2023/0906

30A Fearn House Crescent, Hoyland, Barnsley, S74 0BA

Erection of detached treble garage outbuilding with first floor home office room above and 3no dormer windows set within the roof plane on the front elevation

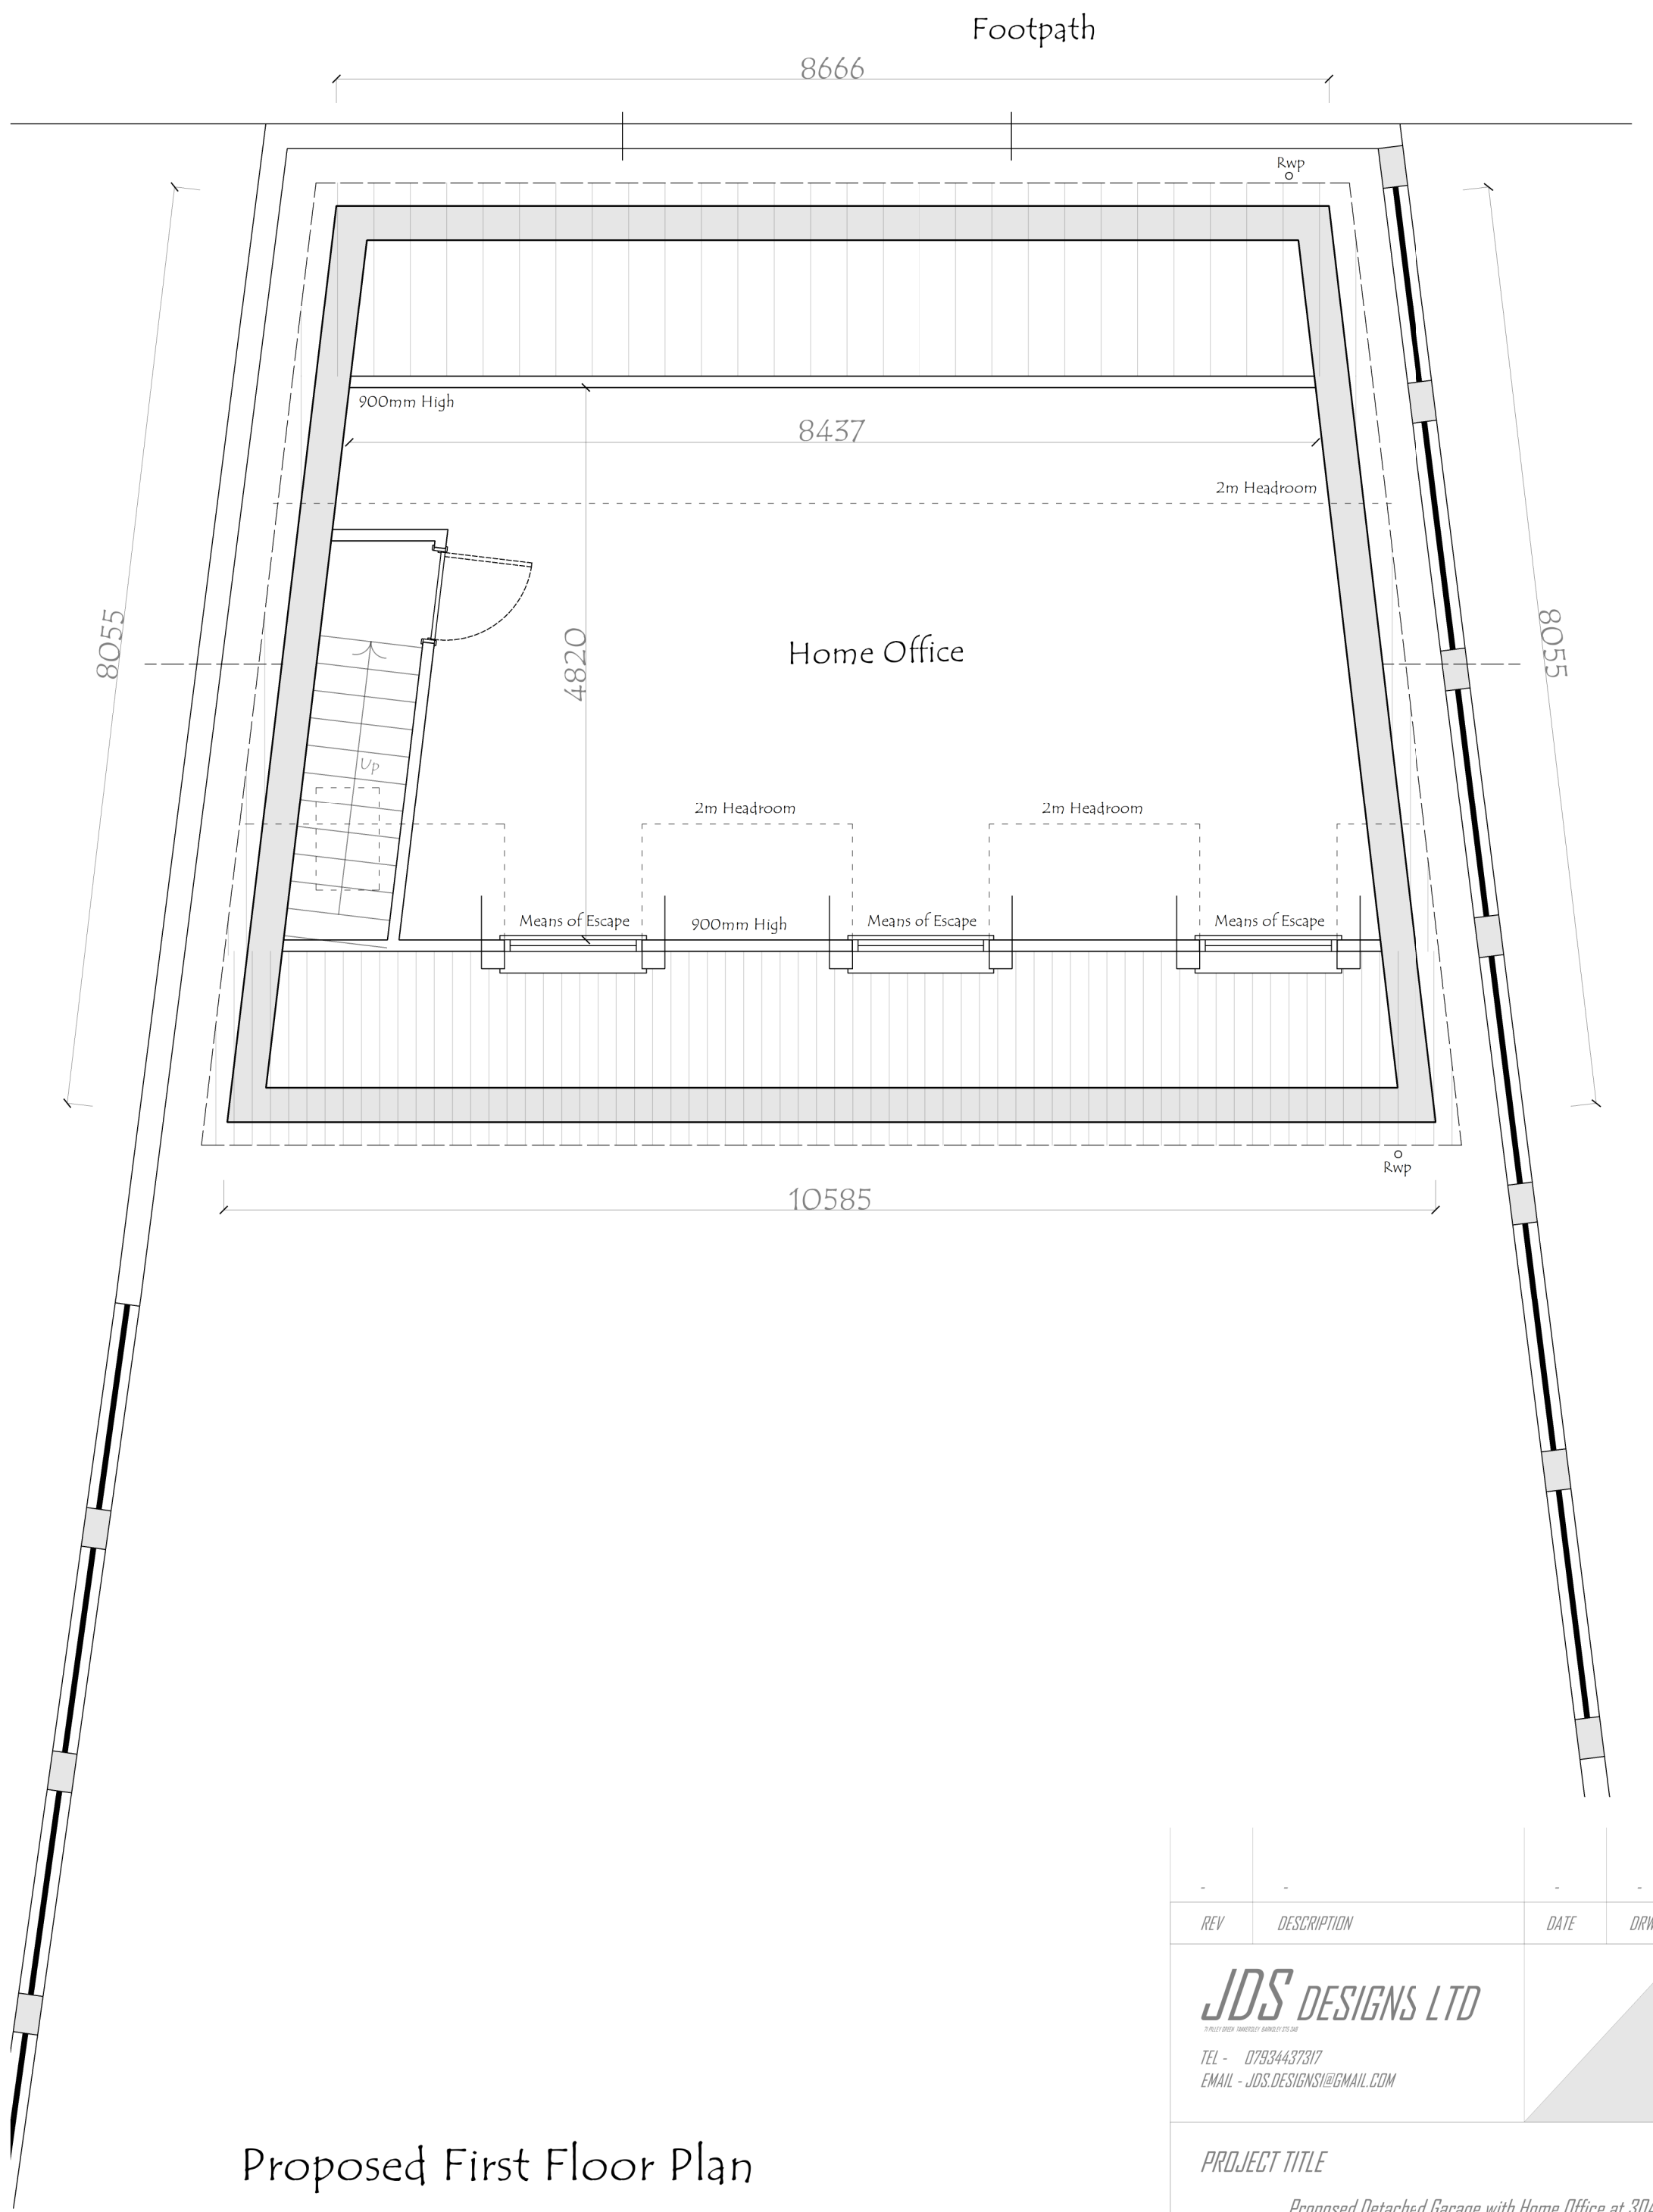
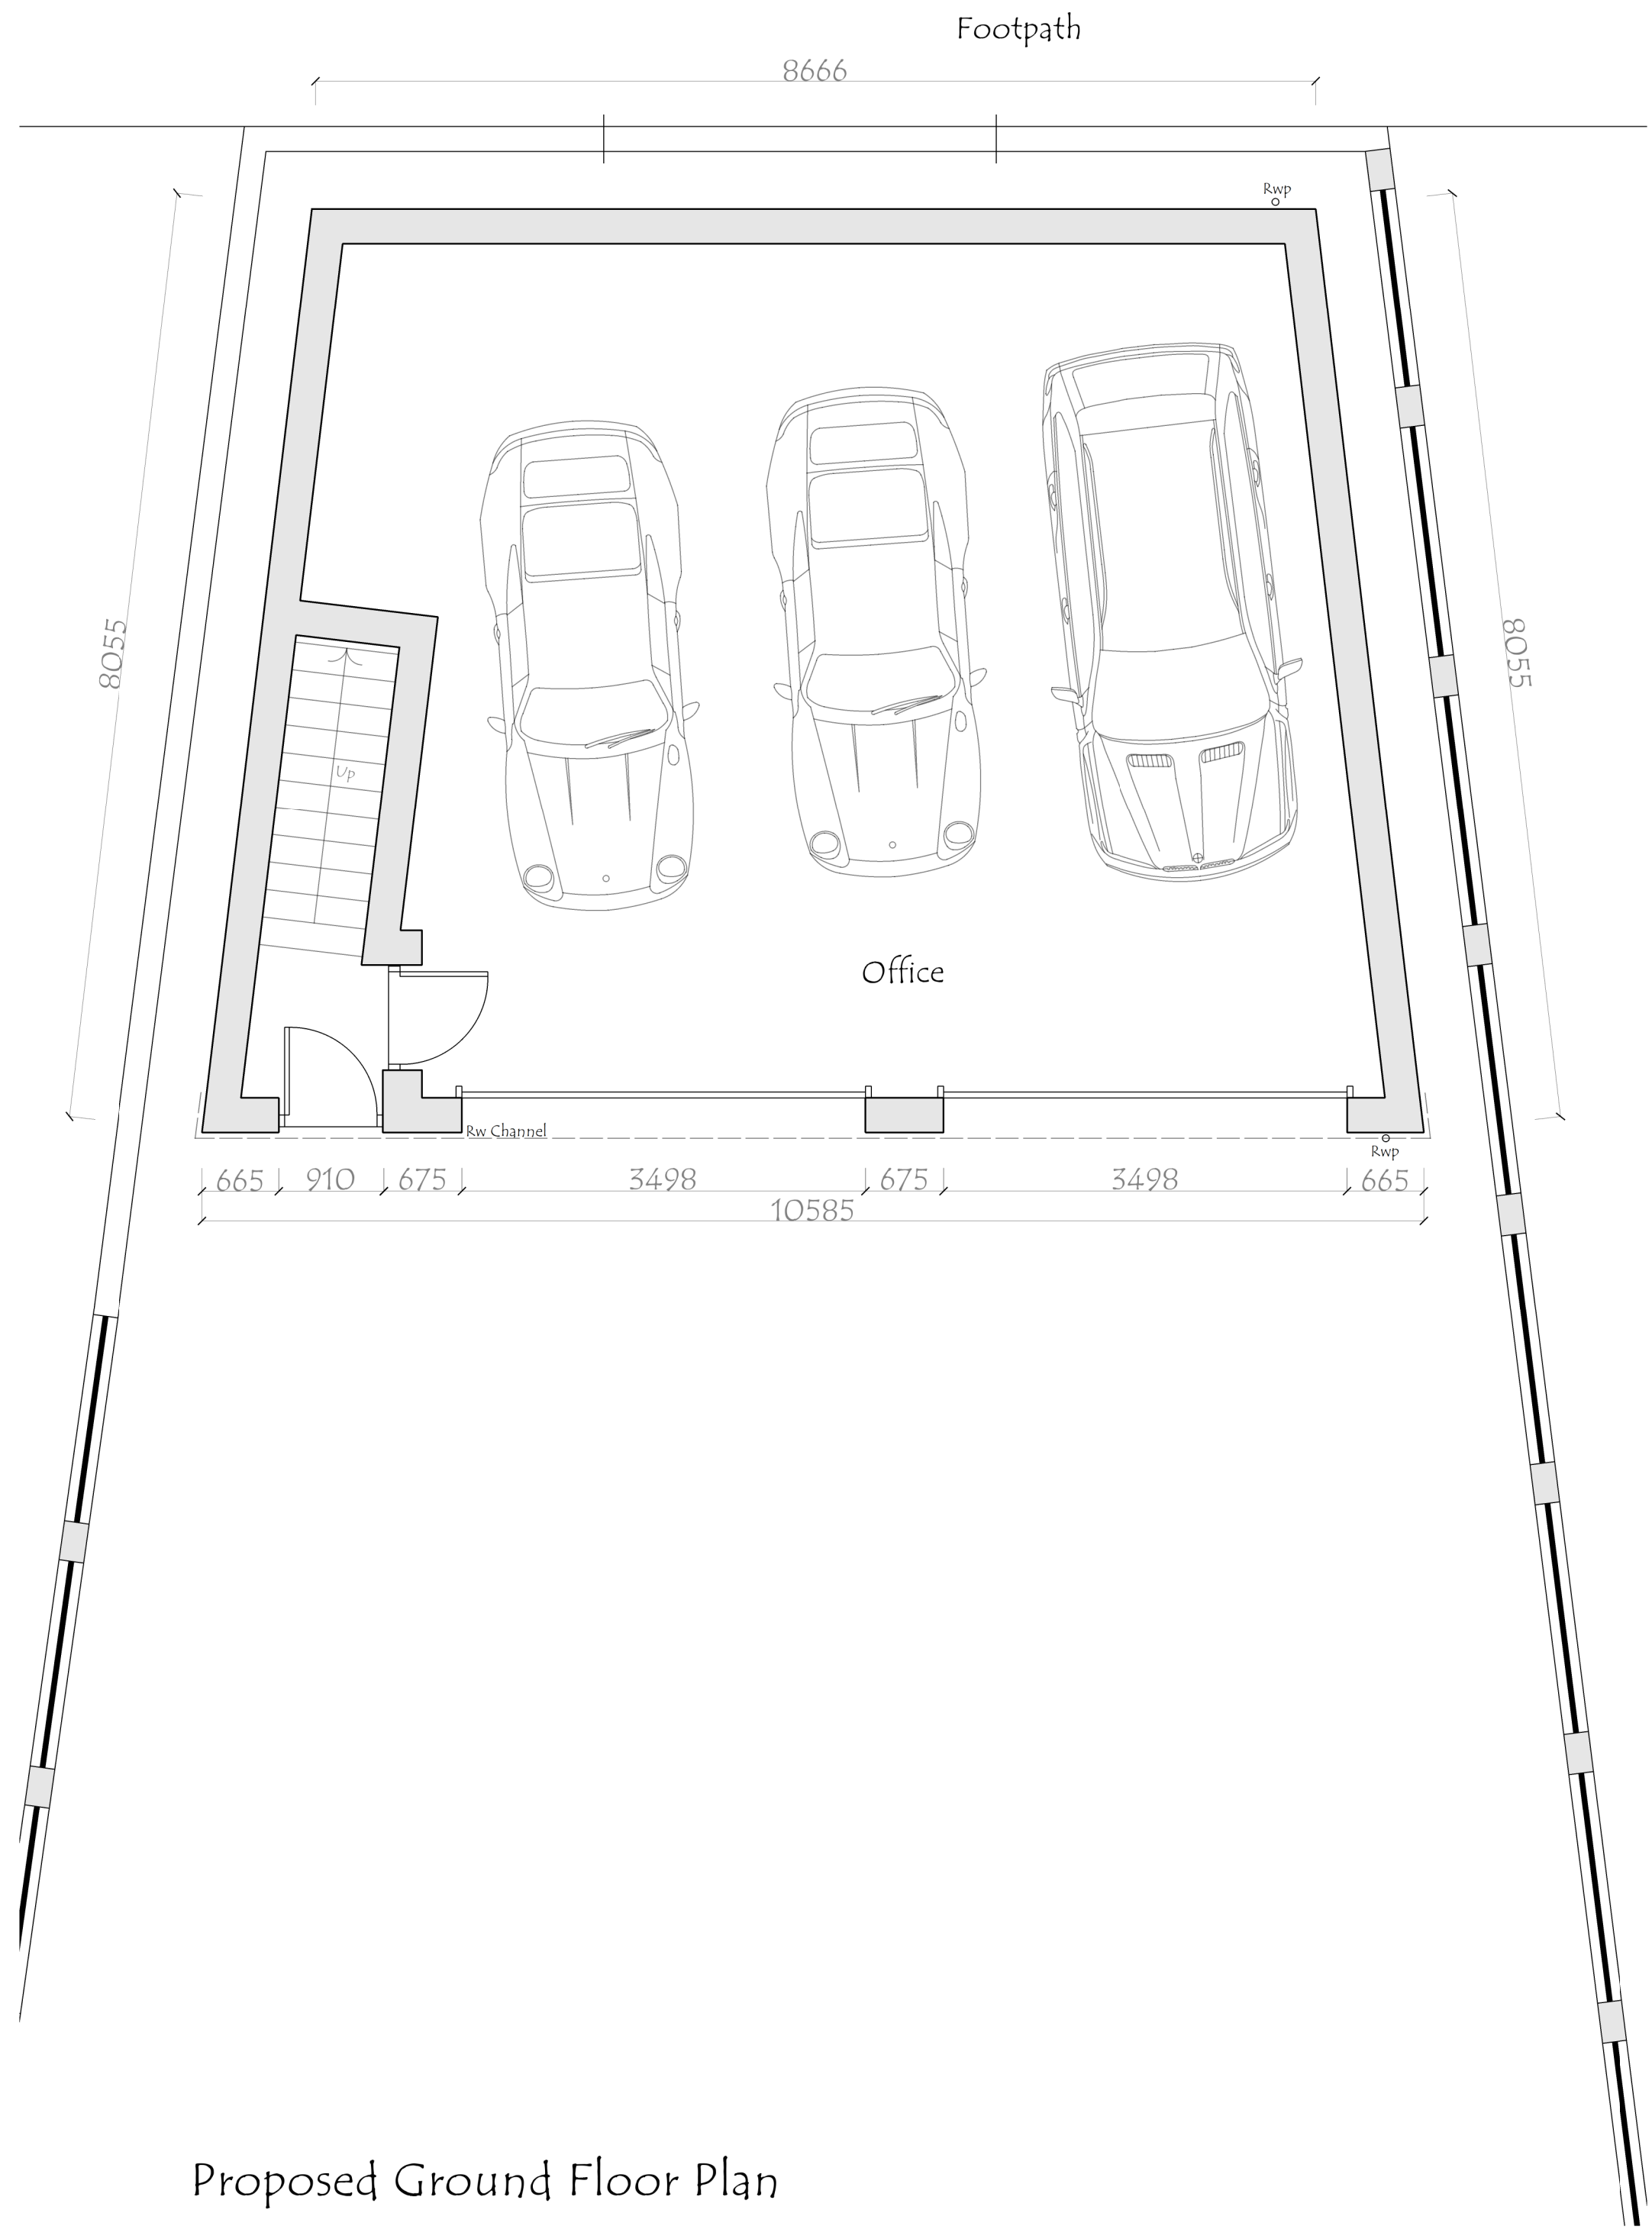
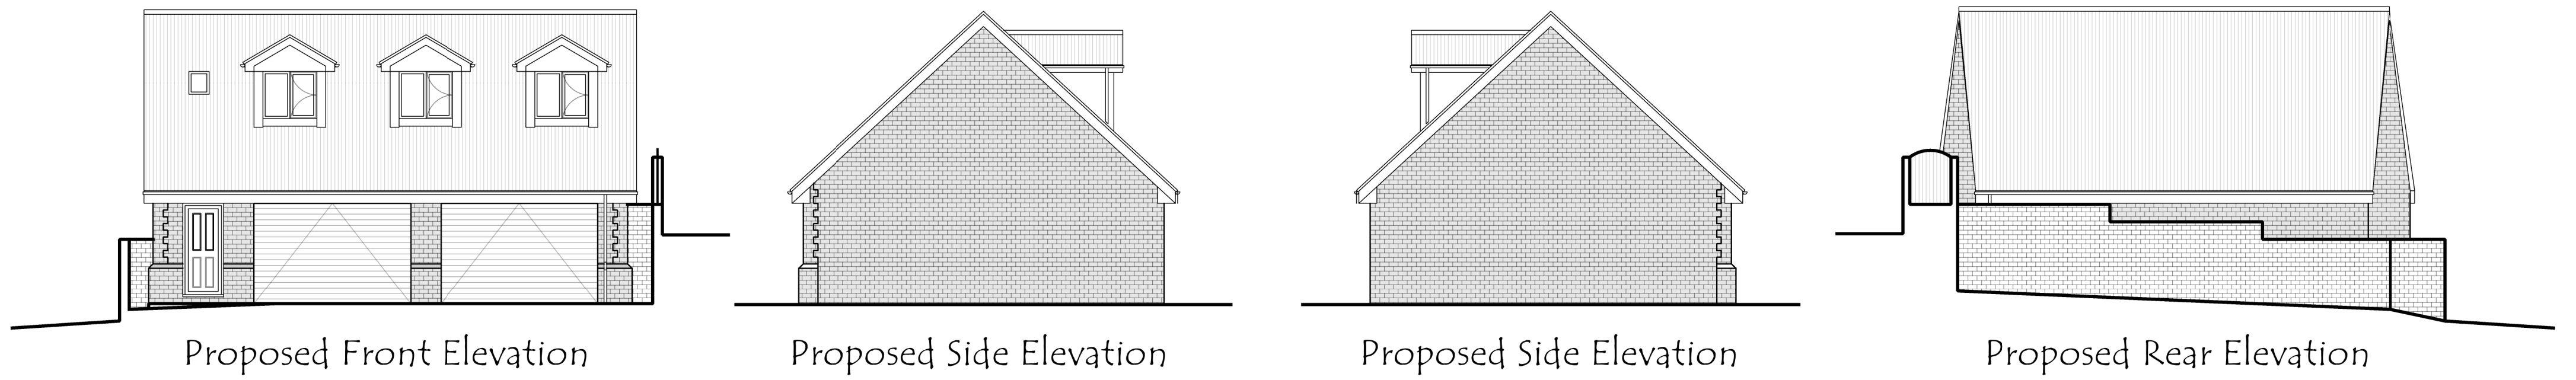
The SPD states that *“detached garages and outbuildings should be single storey structures and the eaves height should not normally exceed 2.5 metres from ground level, whilst the ridge height should not exceed 4 metres”*. The proposed garage has a pitched roof with an eaves height of 2.3 metres which is compliant. However, the proposed garage is proposed to be of two storeys and would have a ridge height of 6.2 metres. The additional storey and roof height over the recommendations of the SPD are not acceptable.

Single storey residential properties are set directly to the side (north & south) of the proposed garage. These properties are 282A West Street to the north and 12 & 14 Fearn House Crescent to the south. The SPD states with regards to habitable room windows that *“a distance of 12 metres should be maintained to a blank gable wall”*. In this case the blank gable wall is that of the proposed garage. The habitable room windows on the rear elevation of 282A West Street are 7 metres away from the proposed garage which is 5 metres short of the recommendation and therefore unacceptable. This weighs substantially against the proposal.

The habitable room windows on the rear elevation of 12 & 14 Fearn House Crescent are 11 metres away from the proposed garage which is 1 metre short of the recommendation and although not as egregious as the impact would be to 282A West Street, it is still unacceptable. The proposed garage would be considerably overlooked from the adjacent dwellings and cause a harmful loss of outlook to the rear elevations of the impacted dwellings. This weighs significantly against the proposal.

The SPD states *“it is not considered appropriate for detached garages to include dormer windows as a way of accommodating rooms in the roof space”*. The proposed garage features dormer windows to its front elevation and alongside the excessive height and scale would give the development an overly residential appearance, rather than that of an ancillary outbuilding. Whilst the dwelling is set back from the road, it will be highly visible from neighbouring properties, and it is considered to punctuate the character of development in the area. It is considered that a garage of this size and scale would appear as an incongruous and dominant feature and would be at odds with the general development pattern of the area and would harm the visual amenity of the area in conflict with policy D1. This weighs significantly against the proposal.

The SPD states that *"proposals for garages will be assessed using the reference of a standard size for a single garage as outlined in the South Yorkshire Residential Design Guide, for double garage proposals a standard floor area size is considered to be 6.5m x 6.5m"*. Whilst it is acknowledged that the proposed garage is proposed to be a triple garage, it is nevertheless considered that it is in conflict with the spd on this point, as the garage would be a very large two storey structure in terms of both footprint and internal floor space. The footprint size of the garage alone measures 77sqm. This is excessive for a domestic outbuilding and would exceed the minimum floorspace expected for a two-bedroom bungalow in the adopted South Yorkshire Residential Design Guide (SYRDG) of 62sqm. Together with the second storey, the internal floorspace would exceed 100sqm which is larger than the minimum size for a 4 bed dwelling as set out in the adopted South Yorkshire Residential Design Guide. The size of the extension is therefore tantamount to the size of a new two storey dwelling. This weighs significantly against the proposal.
